Address: 27 Armitage Road Huddersfield HD34JN

Application number: 2021/93621	
What is the application for?:	Erection of 12 dwellings and associated works (Within a Conservation Area)
Address of the site or building:	Land off, Fullwood Drive, Golcar, Huddersfield, HD7 4JH
Postcode:

Description: PROPOSED SITE PLAN & 3D VIEW

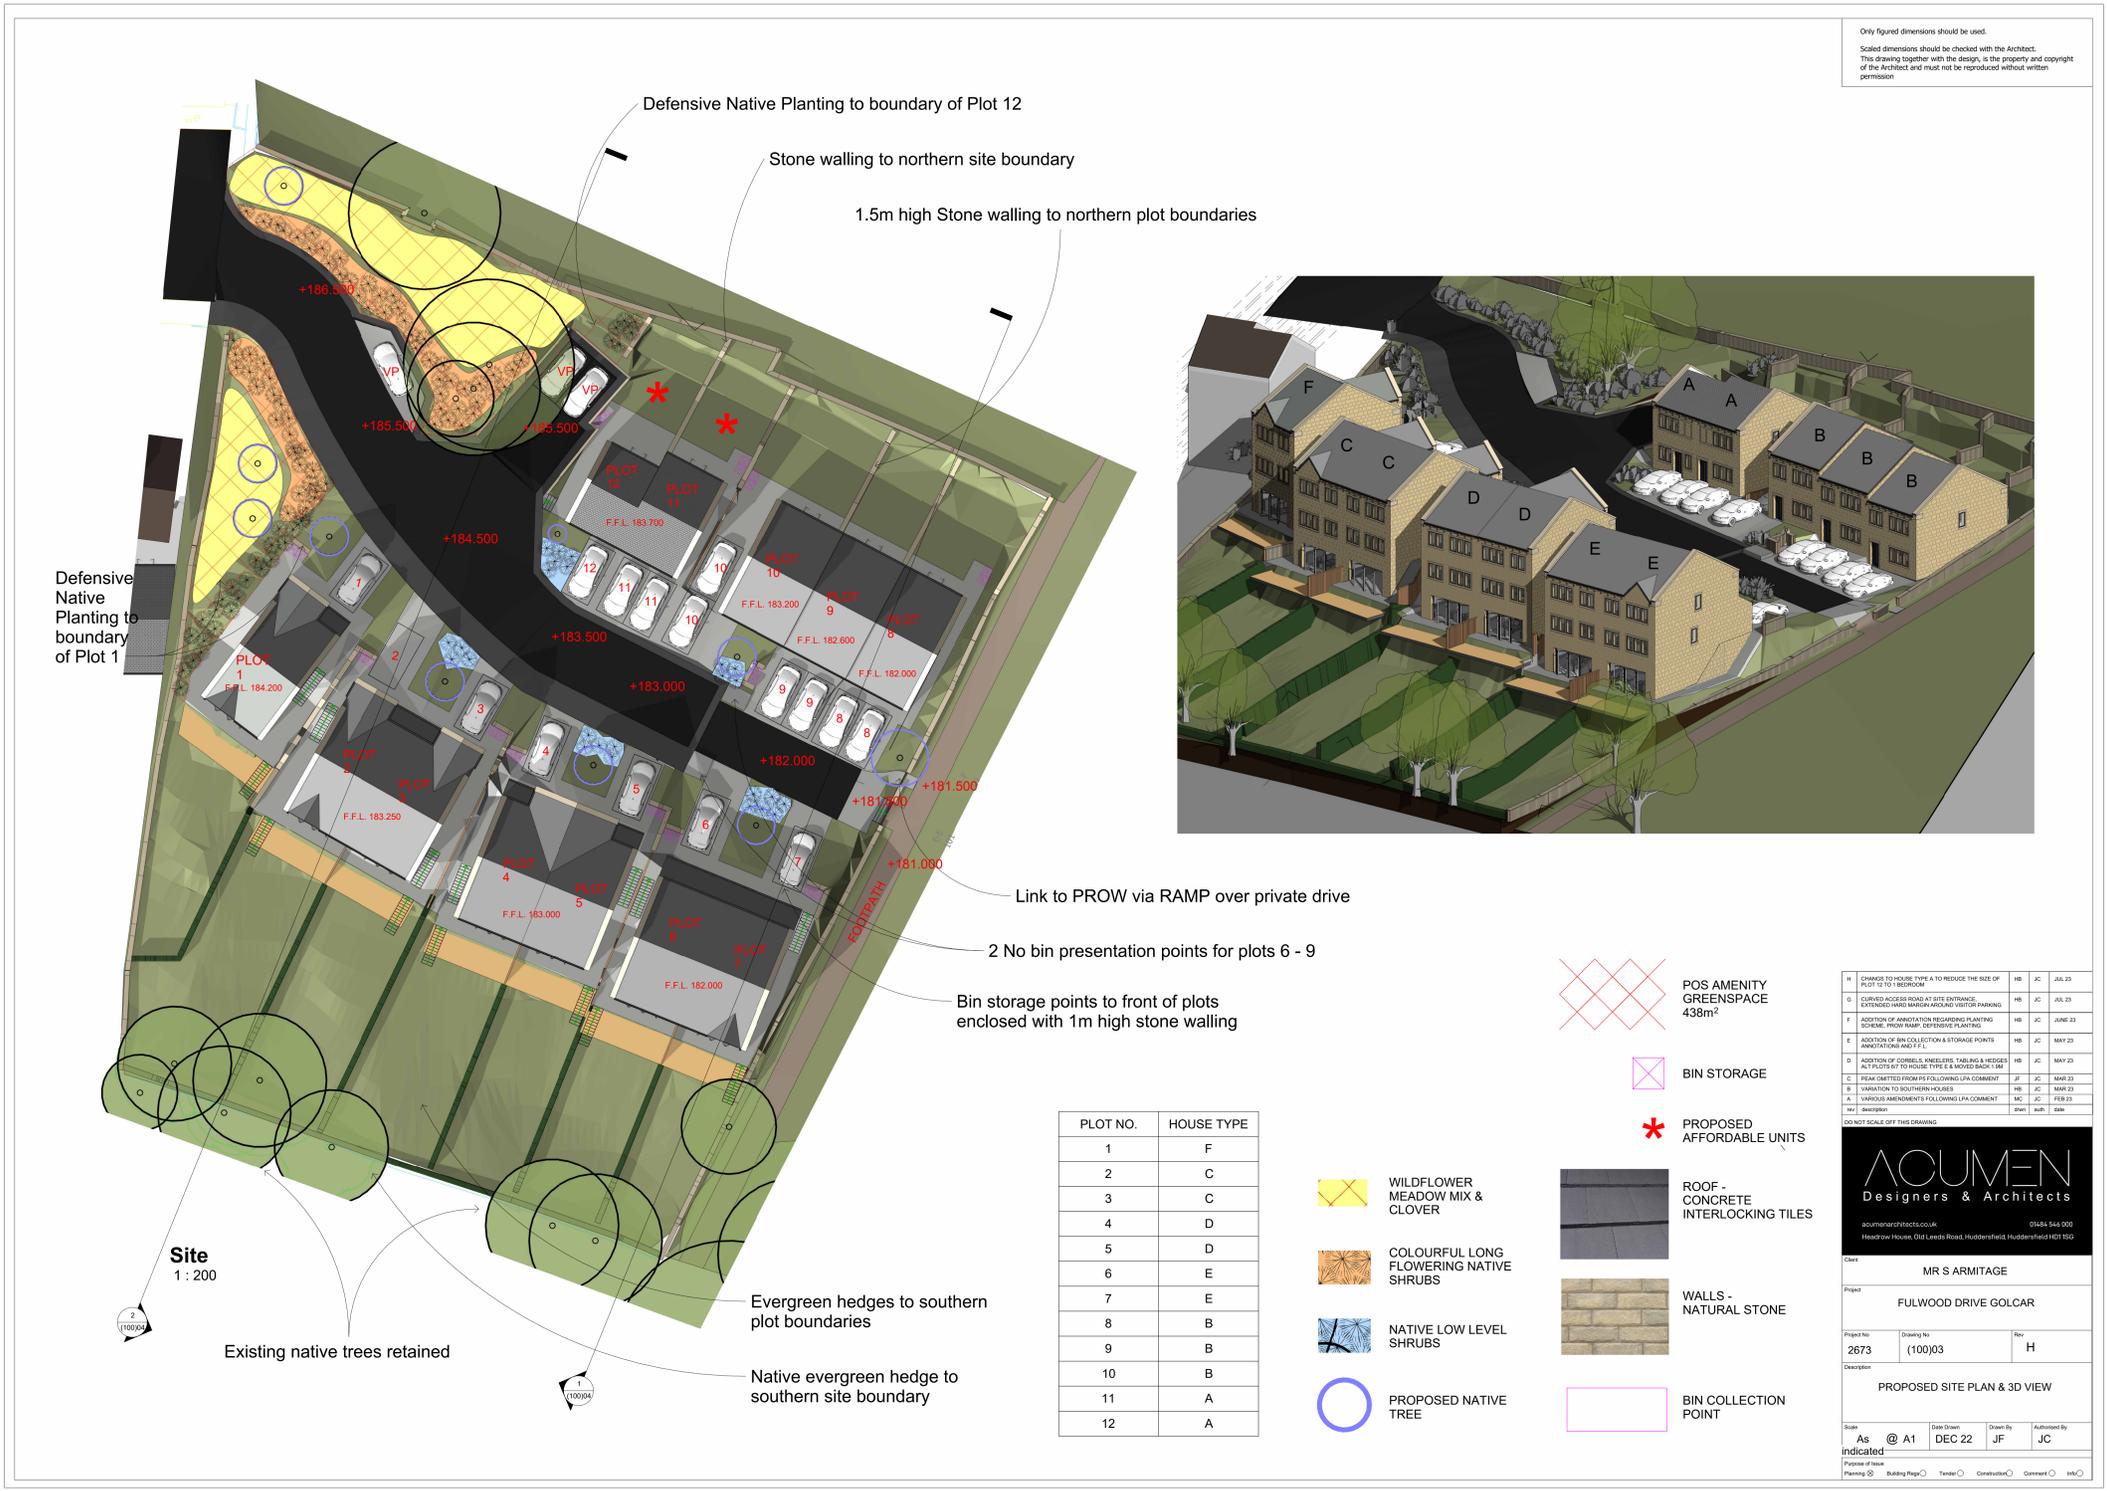
Type of comment: An objection	
Do you wish your comments to be published on the website anonymously?	No
Have the ecology reports been updated from 2017. I would like to see them.
